ENG-SF21012-R1-GEC-redlines.pdf Markup Summary

Subject: Stormwater Comments Color
Page Index: 1
Date: 3/9/2021 11:28:26 AM
Author: CFurchak
Color: ■
Layer:
Space:
Page Label: [1] C2.0 COVER SHEET

PROJECT NO.  
096302009  
SHEET  
**C2.0**

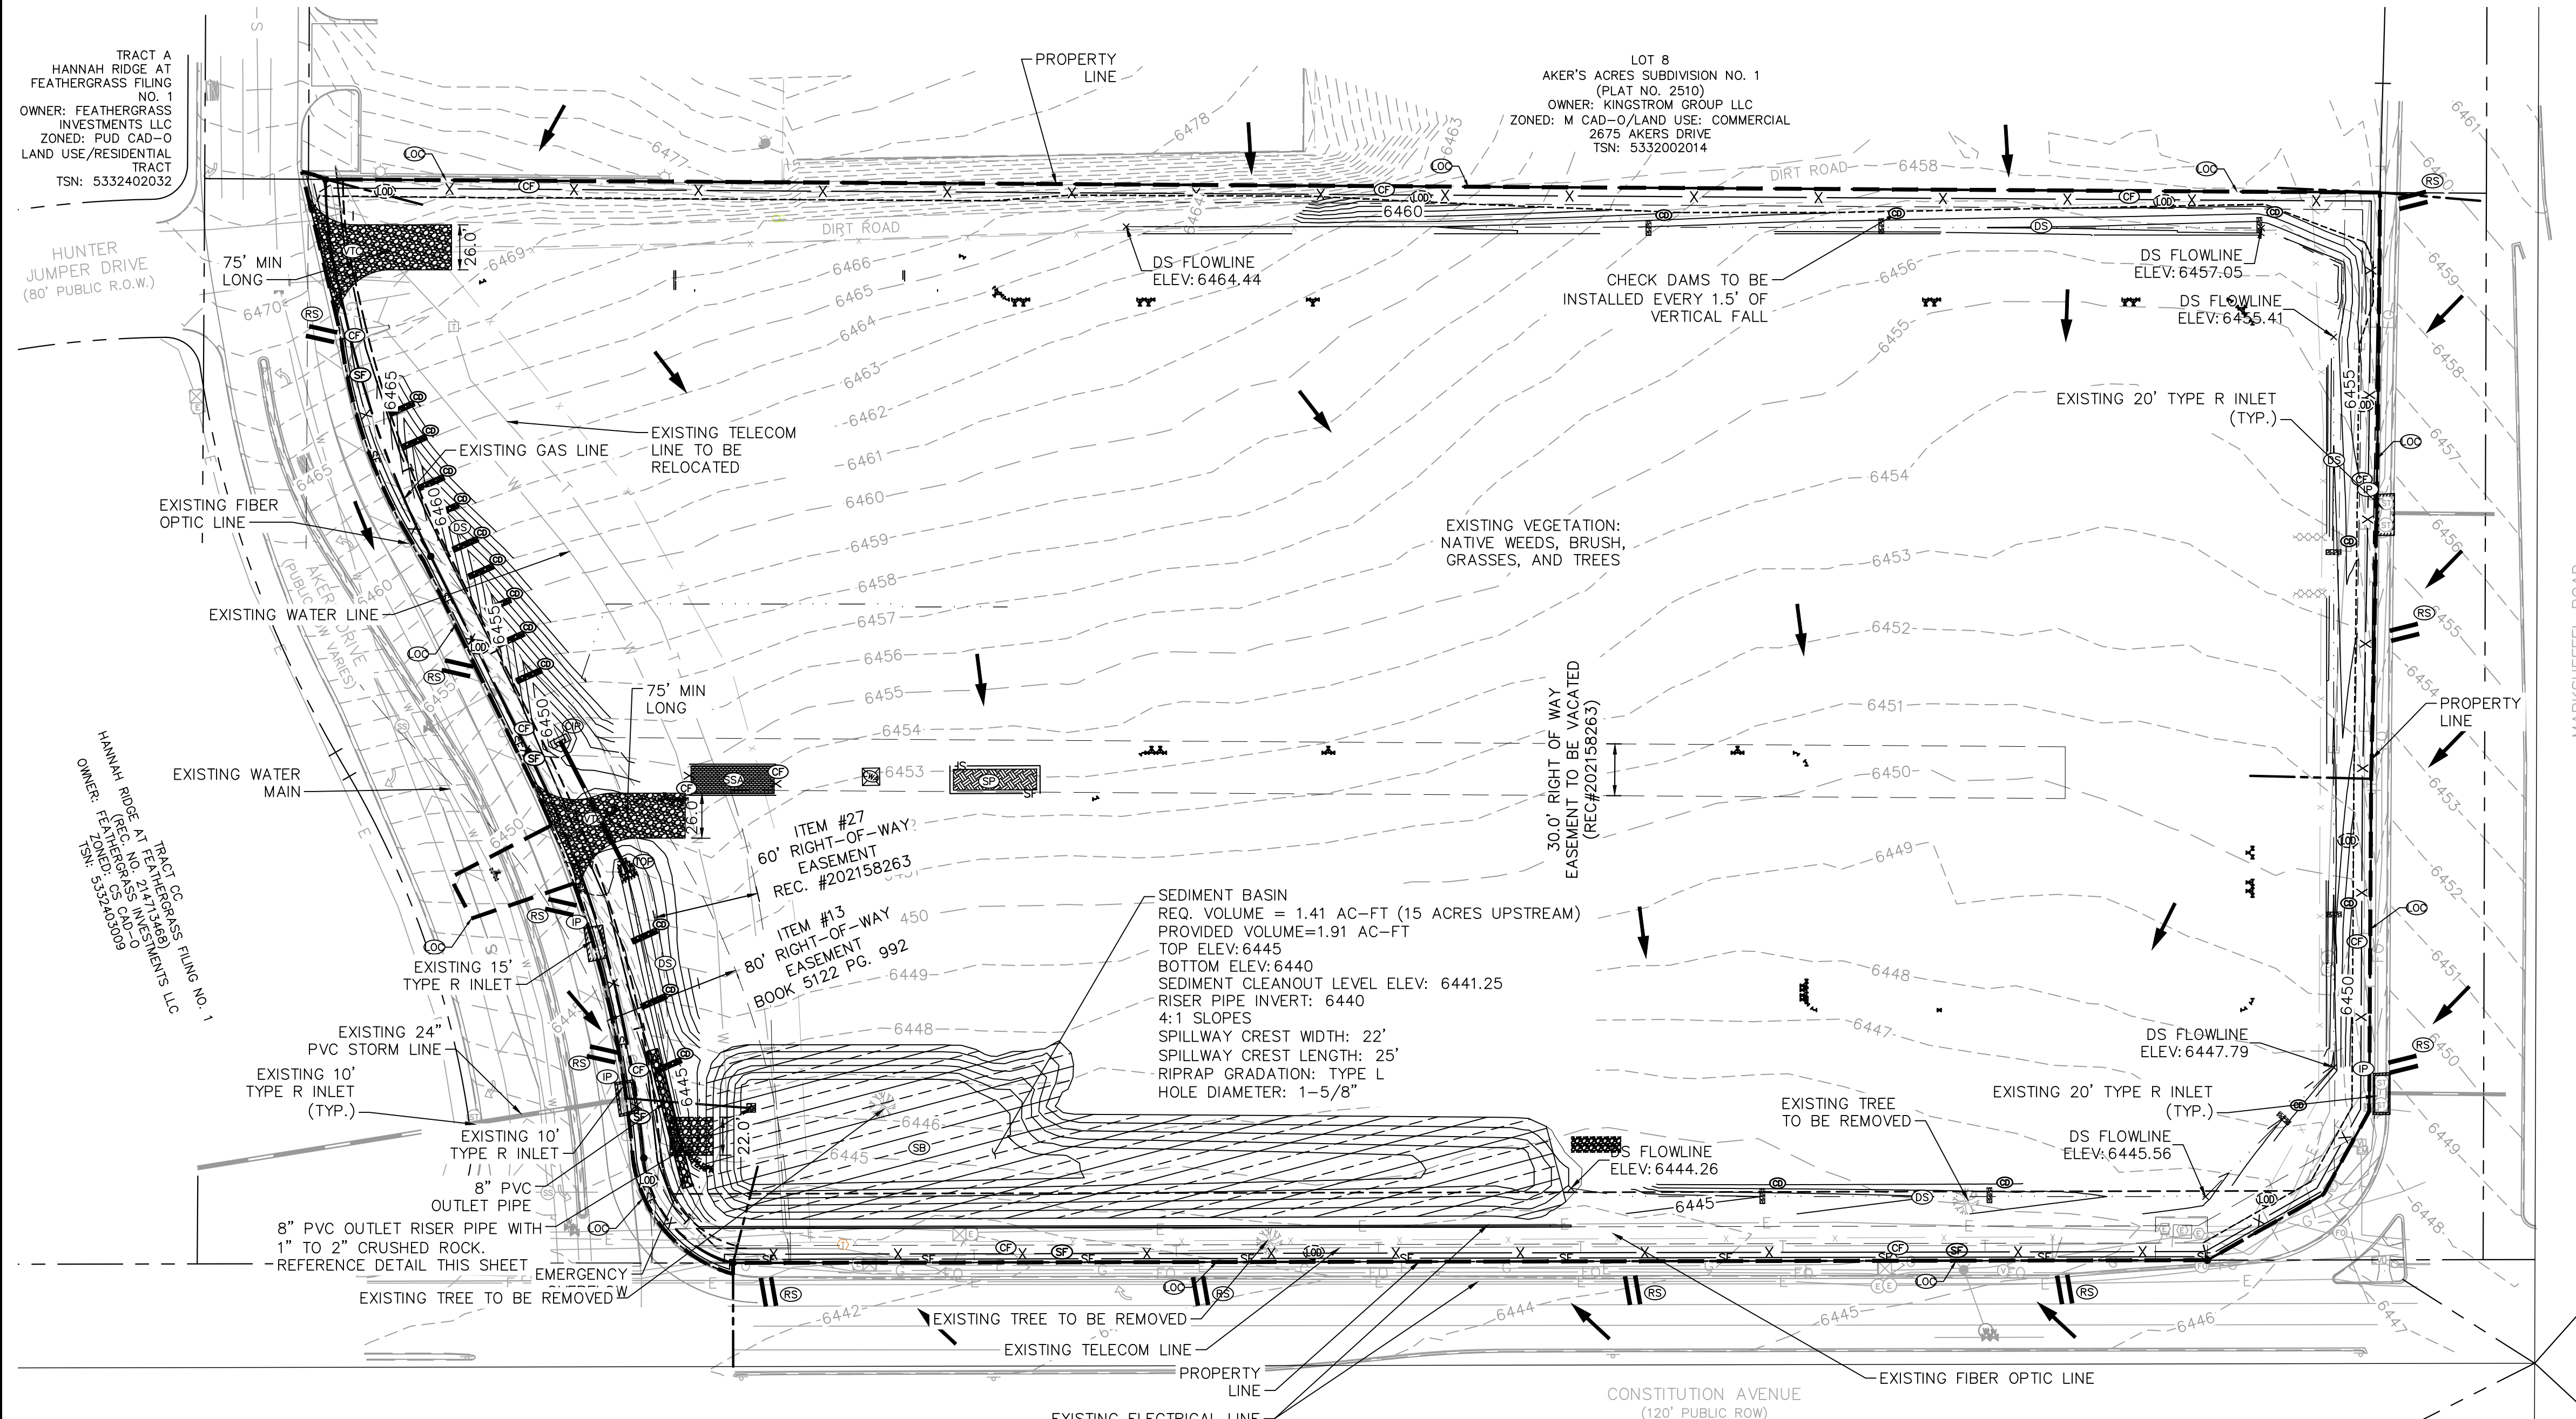
SWMP states that the
was prepared by
Kumar and Associates, dated
9/20/2020.
Please confirm.

SWMP states that the soils report was prepared by Kumar and Associates, dated 9/20/2020 Please confirm.

Please use signature blocks for a Standalone GEC Plan (See GEC Checklist Items ff and hh)

PROJECT NO. 096302009  
 SHEET C2.1

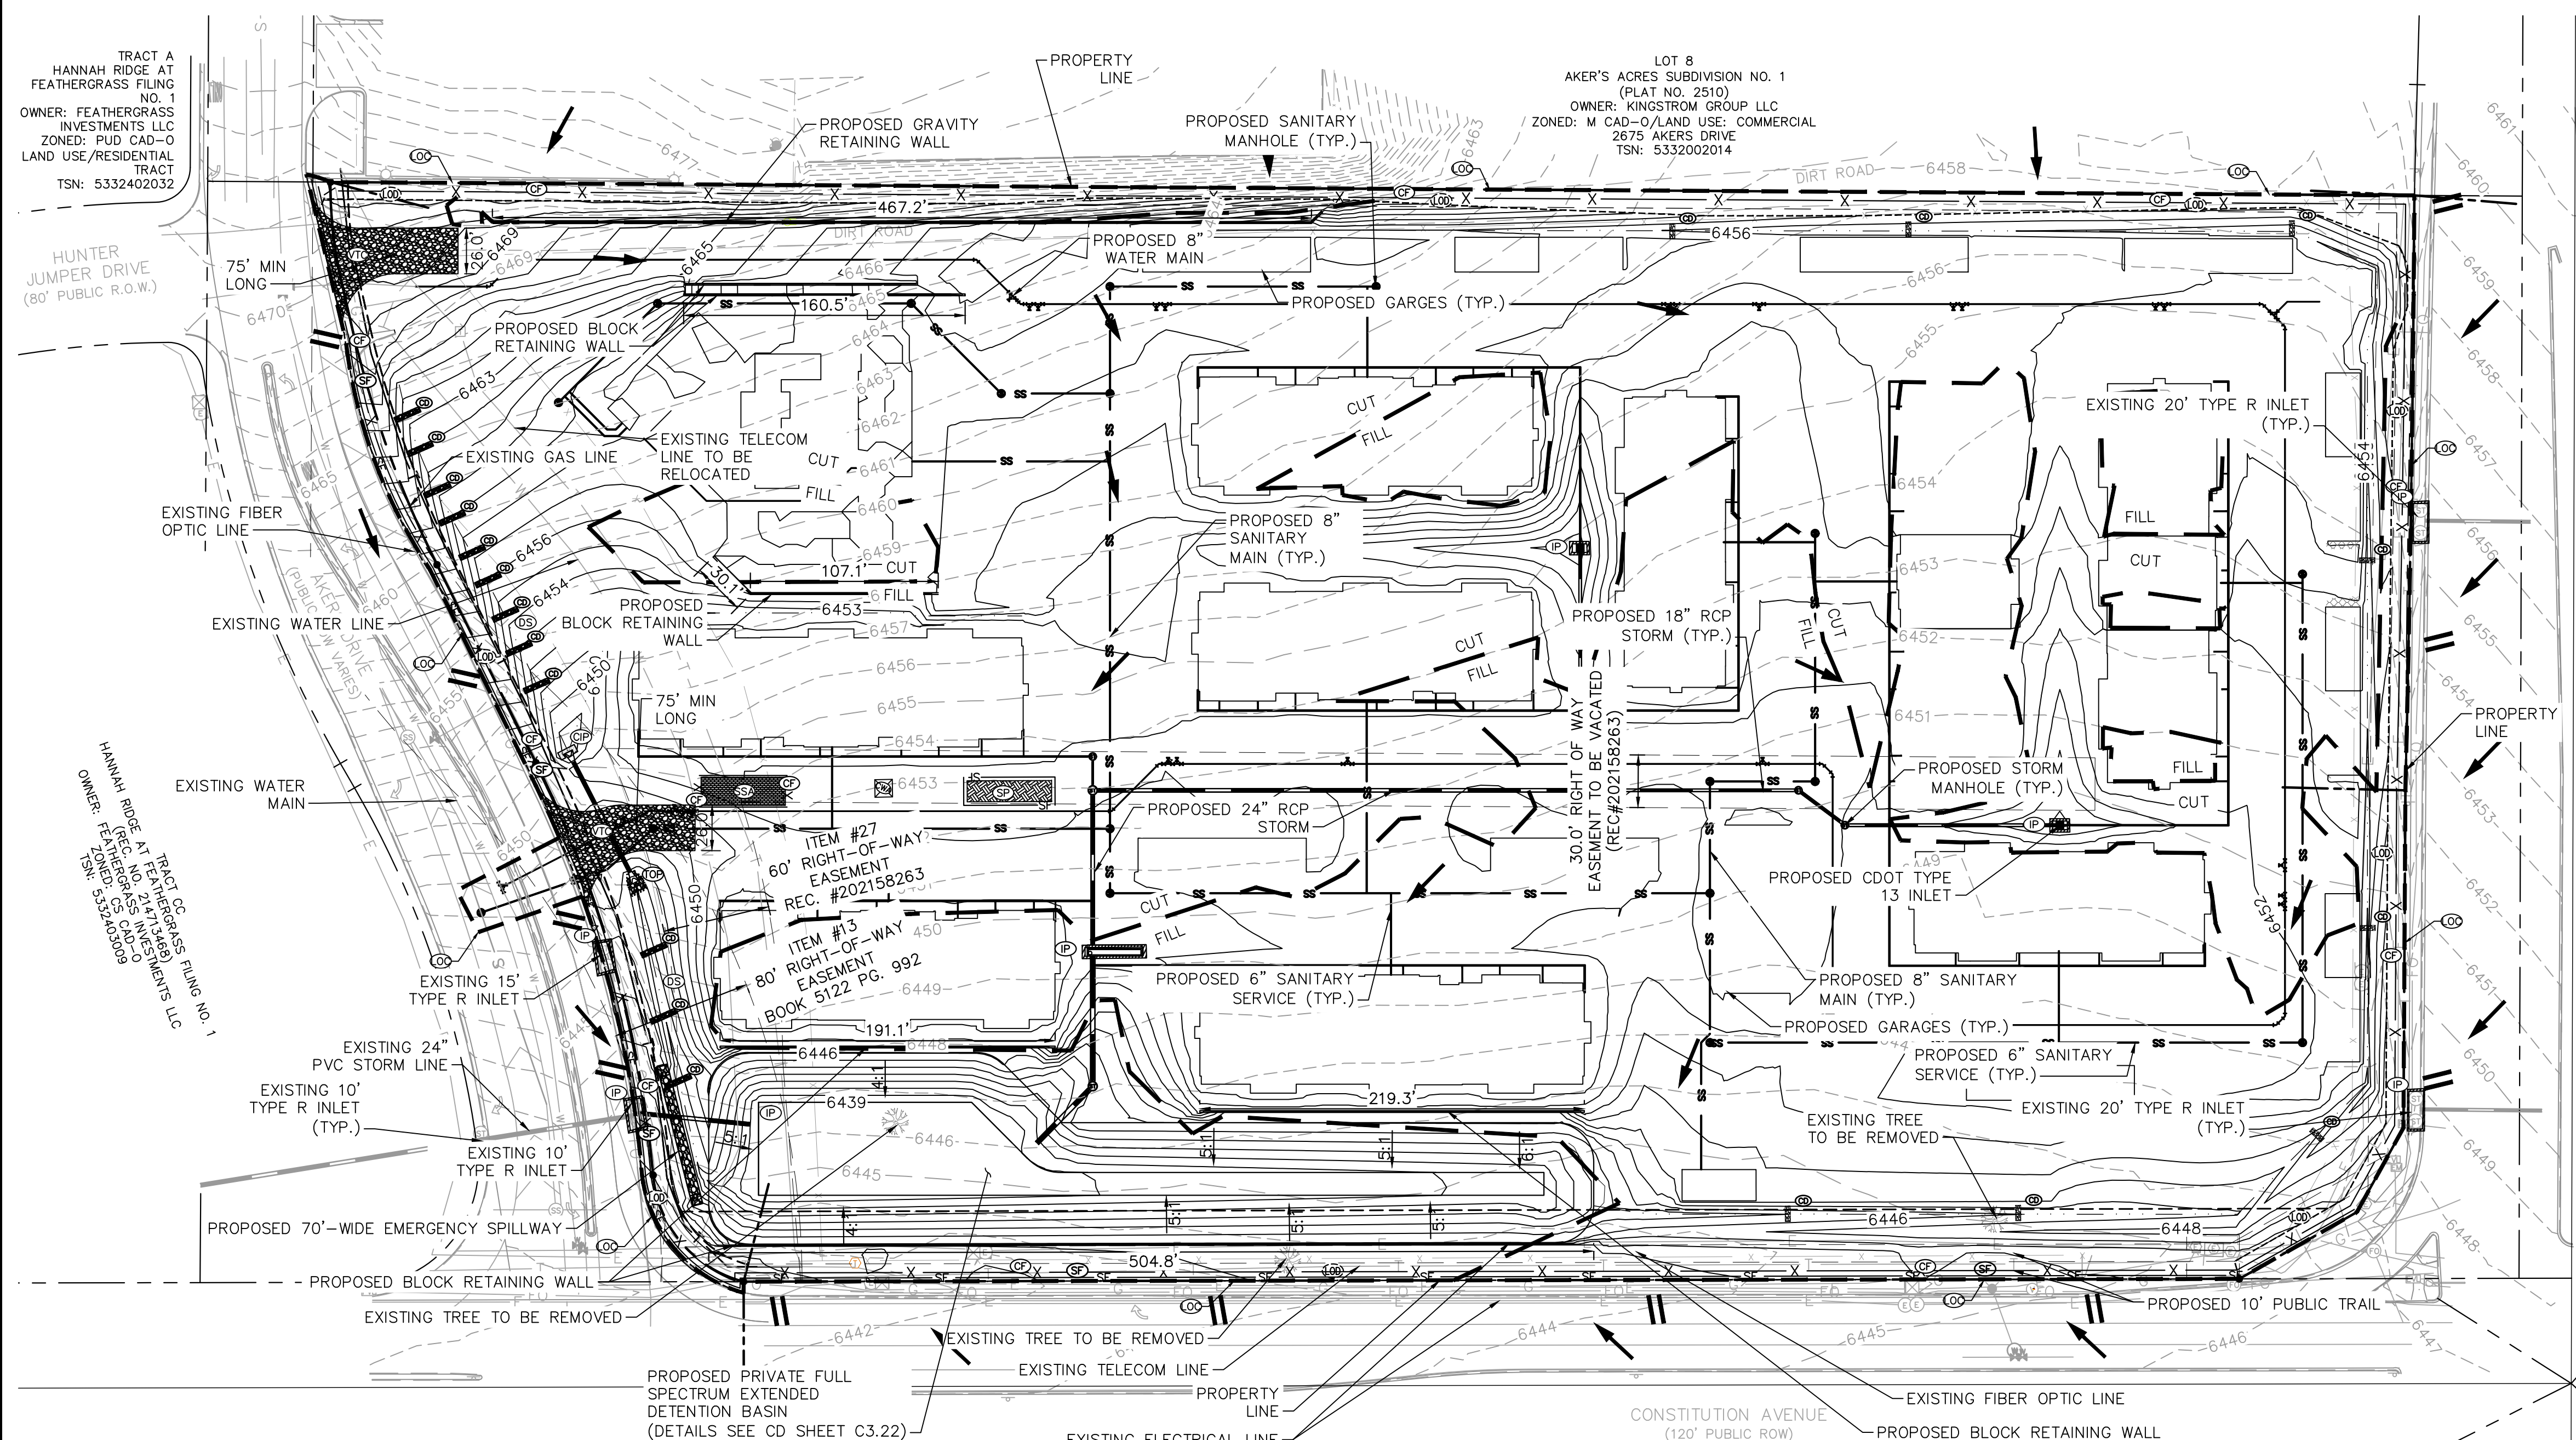
show drainage swale proposed contours. Show symbol on Legend

provide length of spillway and riprap gradation

If existing trees are to be removed, please state as such

**C2.2**

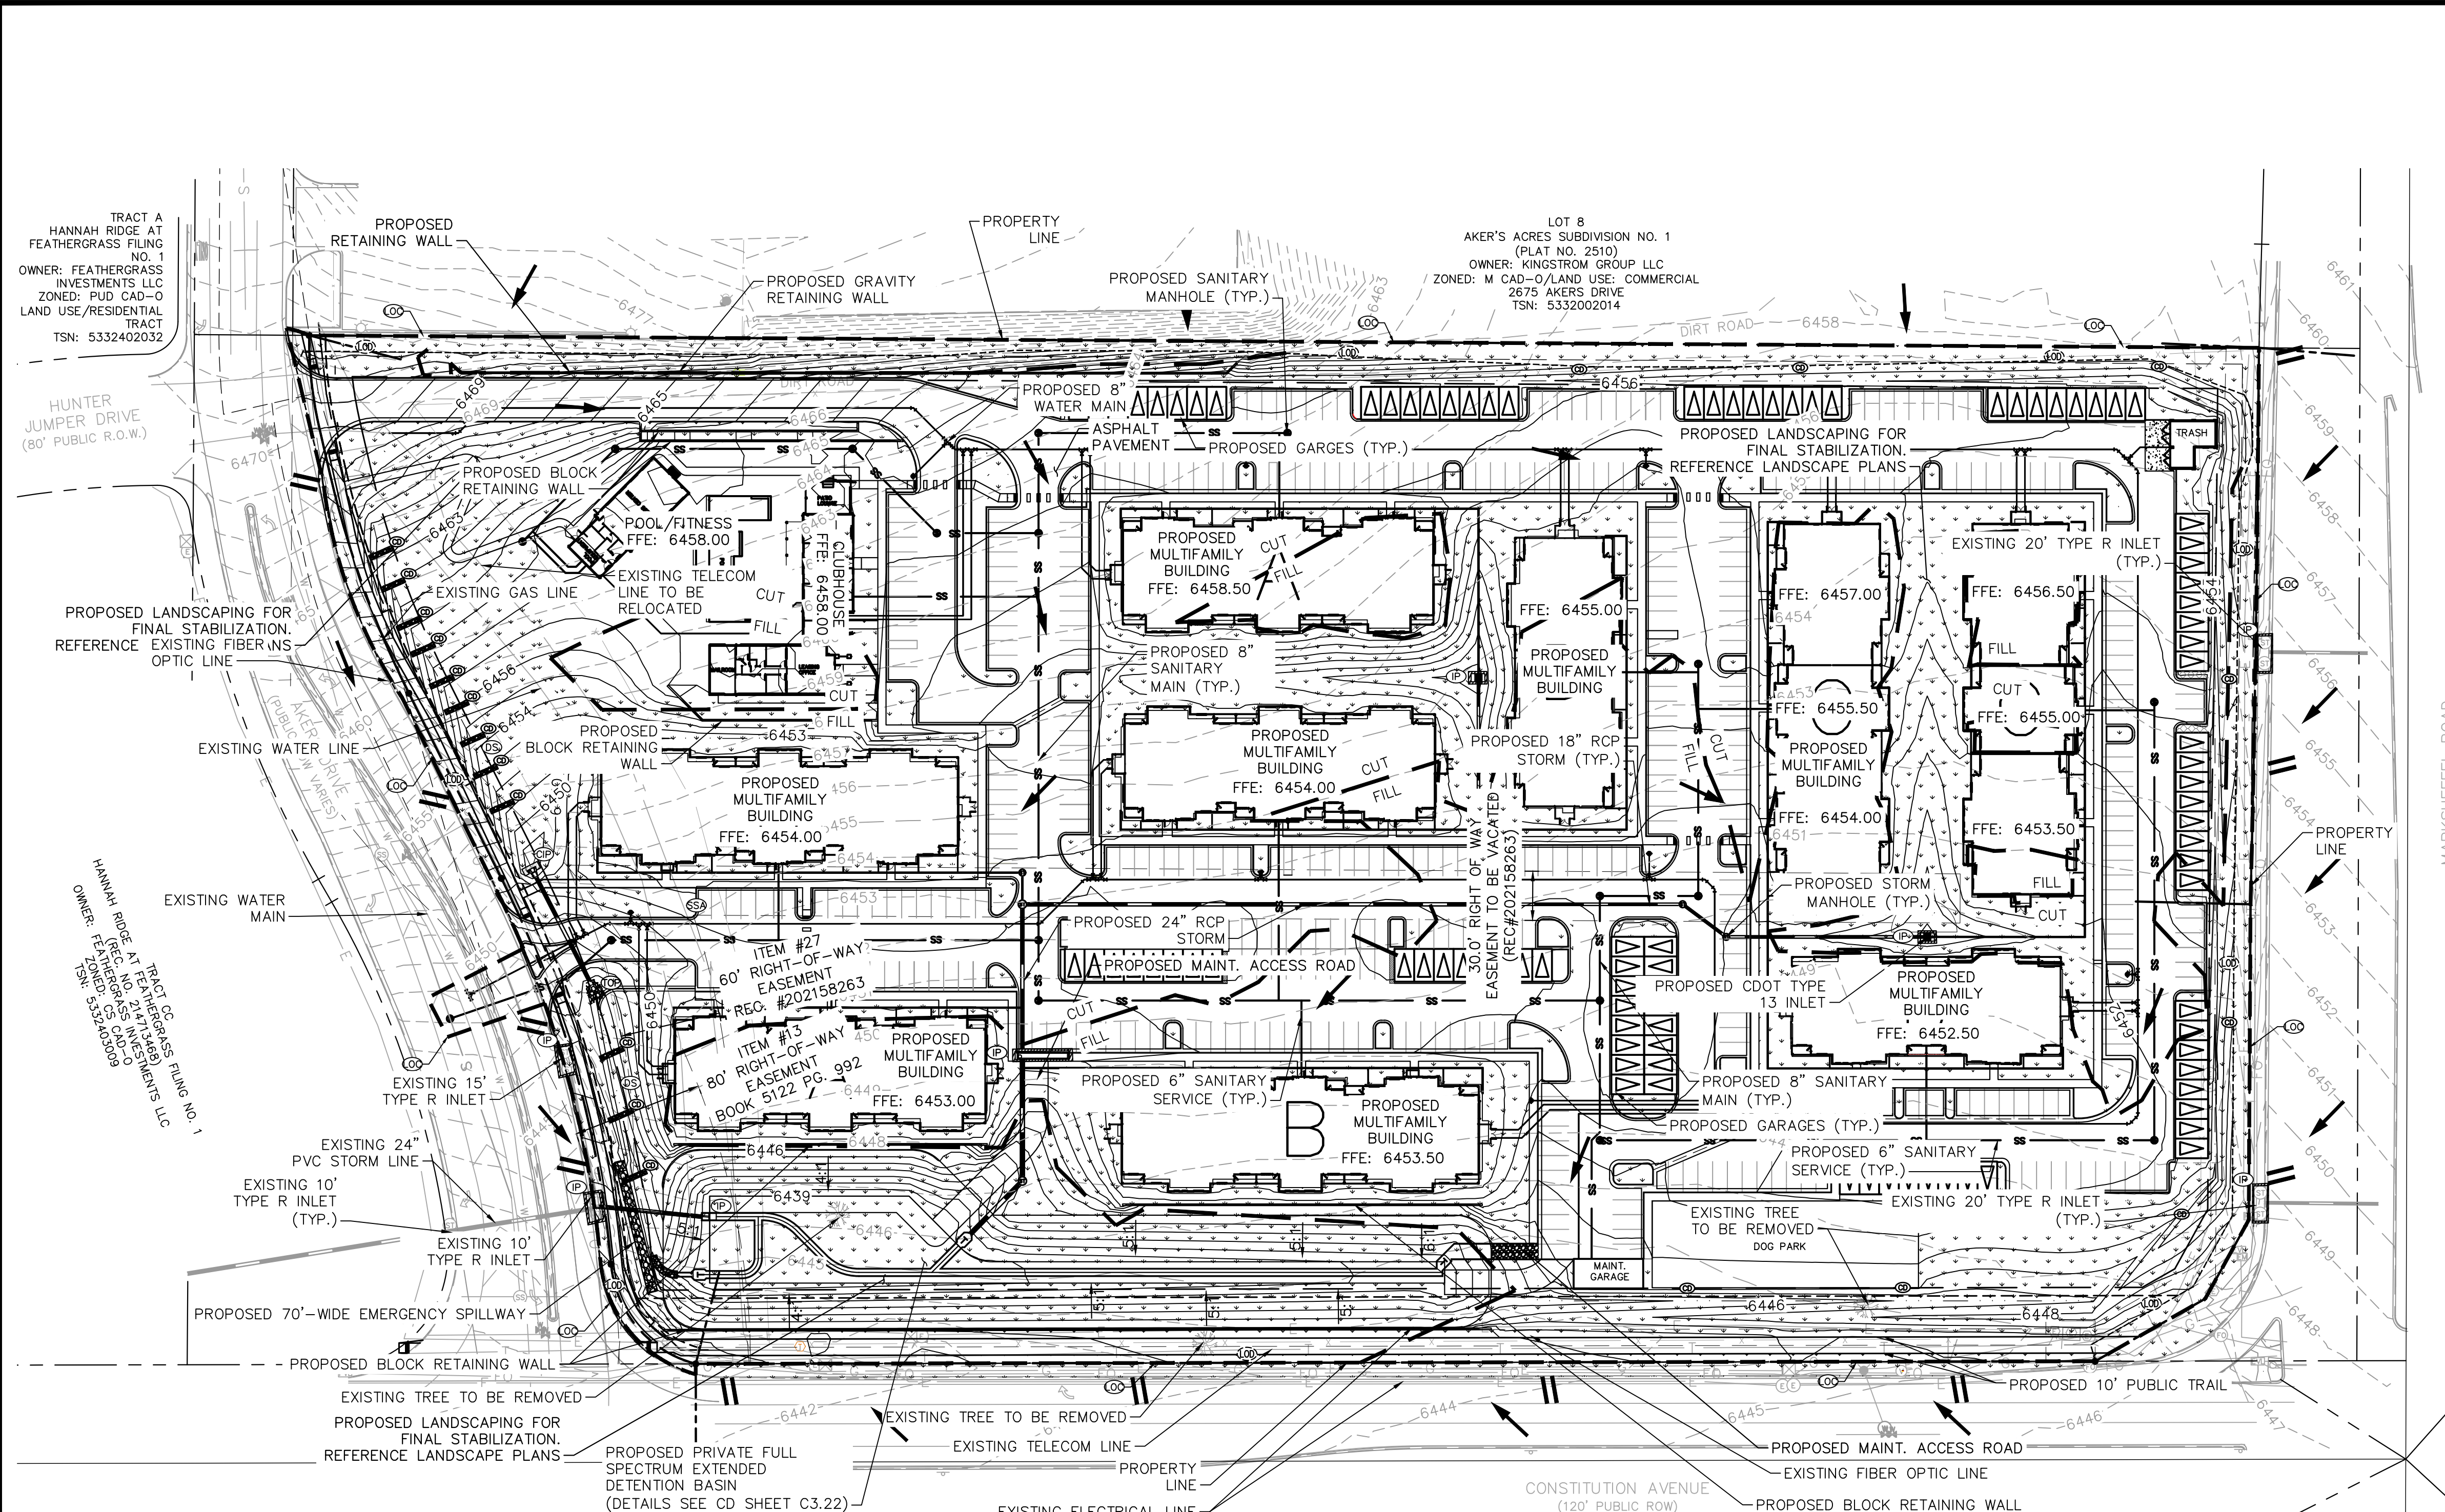
remove all proposed buildings as they are not part of the interim phase

add a note stating that the pond details are in the CDs Sheet C3.22

provide retaining wall details (dimensions, material, etc.)
